Thanet Extension Offshore Wind Farm

Appendix 18 to Deadline 7 Submission: Statement of Common Ground – Port of London Authority

Date: June 2019

Revision D

Sea Zones Plan – Reduction in red line boundary

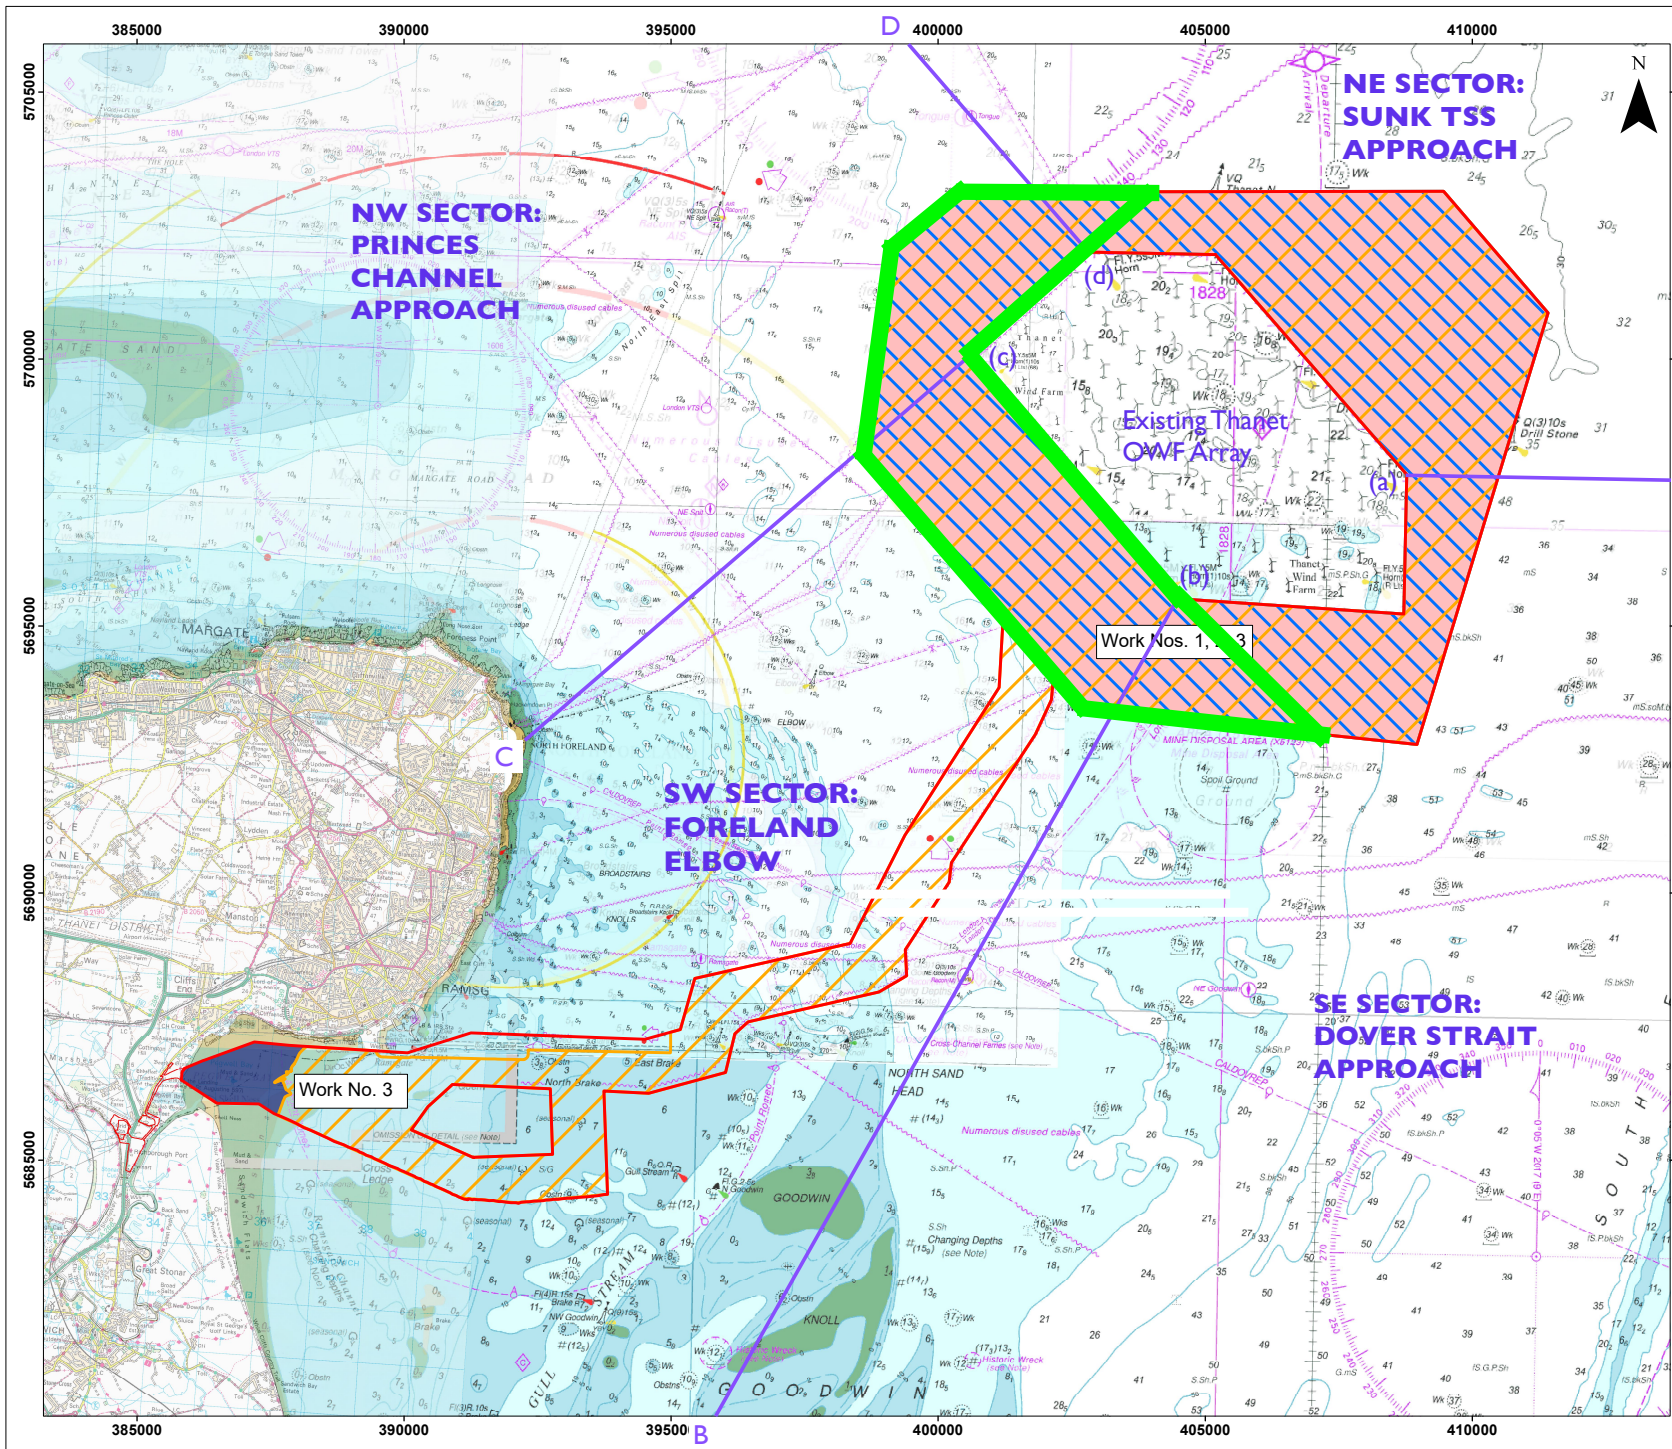
Discussion Point	Thanet Extension Position	PLA Position	Final Position
		<p>plan showing the extent of the scheme RLB. In fact, the area by which the RLB had been reduced was minimal.</p> <p>The PLA acknowledged that its concerns had been considered, and that an attempt had been made to address them. However, the PLA still has a number of concerns regarding the proposal. The extent reduction of 50% was a 50% reduction of the north west tip, which is a very small part of the overall proposed extension area; in practice, the reduction was therefore much smaller than the figure of 50% suggests. The reduction does not address PLA concerns regarding the reduction in sea room to the west of the windfarm, which affects the shipping corridor running north west/south east between the windfarm and the shore.</p>
